## DEPARTMENT OF PUBLIC WORKS

### MEMORANDUM

DATE: April 30, 2018

SUBJECT: Evergreen Ridge P.U.D. – Parcel B, Division 2

**EVERGREEN RIDGE P.U.D. - PARCEL B, DIVISION 2**  
**A PORTION OF THE NORTH 1/2 OF SECTION 12,**  
**TOWNSHIP 20 NORTH, RANGE 14 EAST, W.M.**  
**KITTITAS COUNTY, STATE OF WASHINGTON**

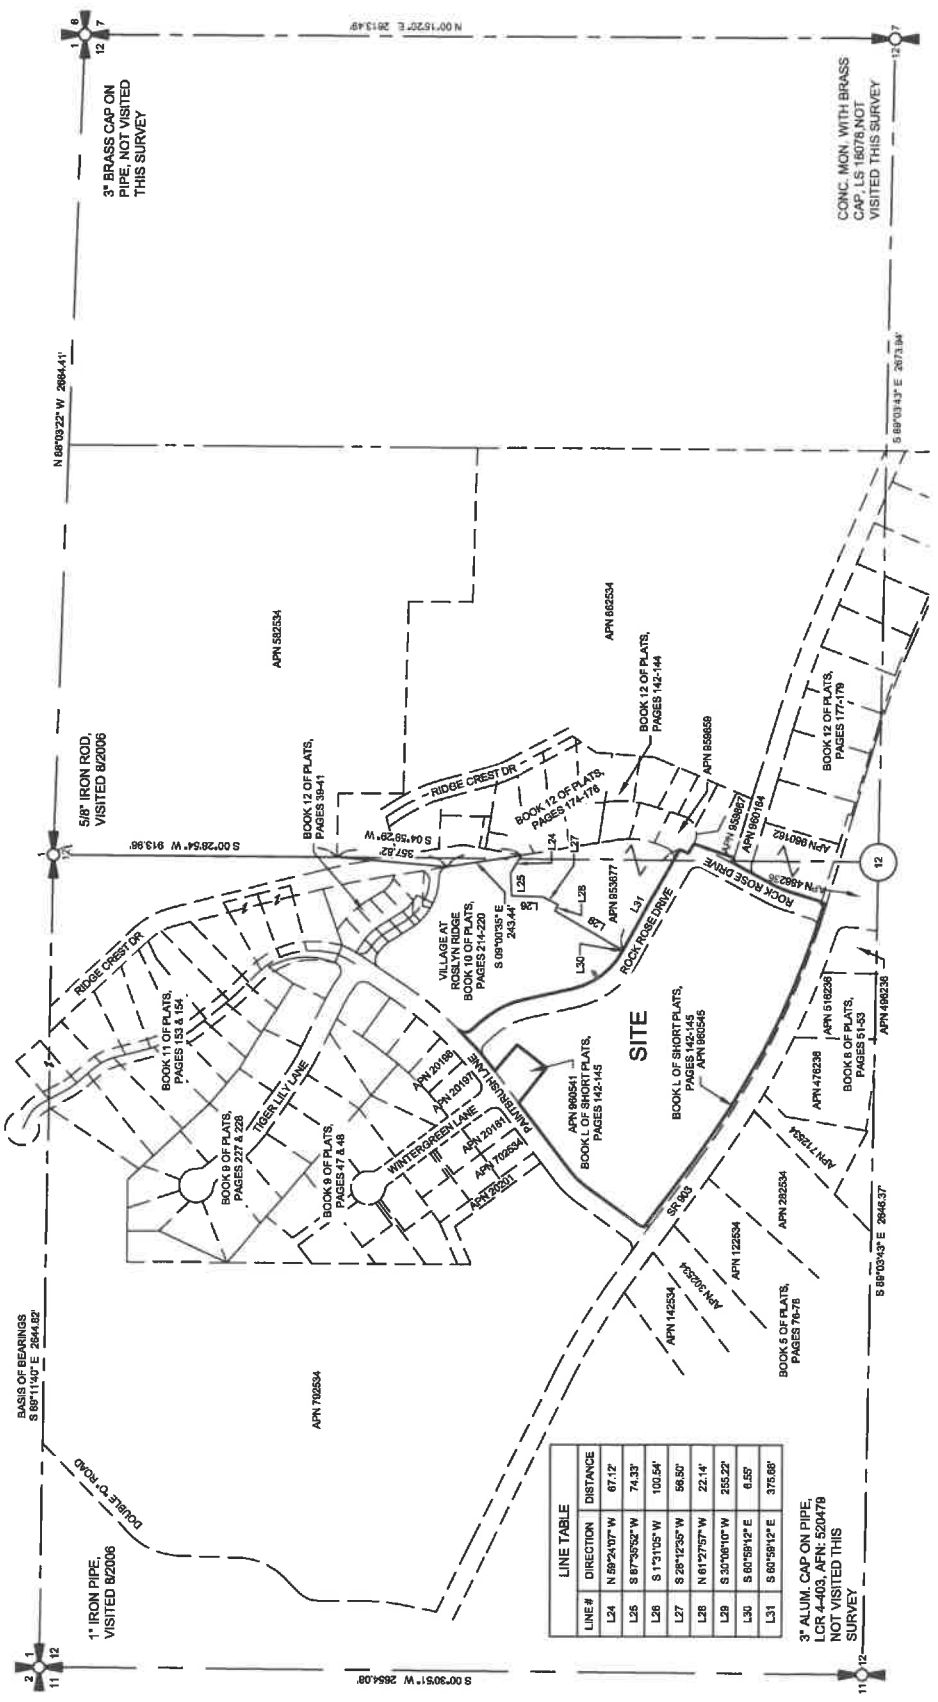
- 1) A cul-de-sac is required on Paintbrush Lane and needs to be shown on the face of the plat, due to the roadway not having direct access onto SR 903.
- 2) The connection of Paintbrush Lane onto SR 903 should show that it is for emergency access only, not a thru route.
- 3) Show Maywood Lane Road Tract.
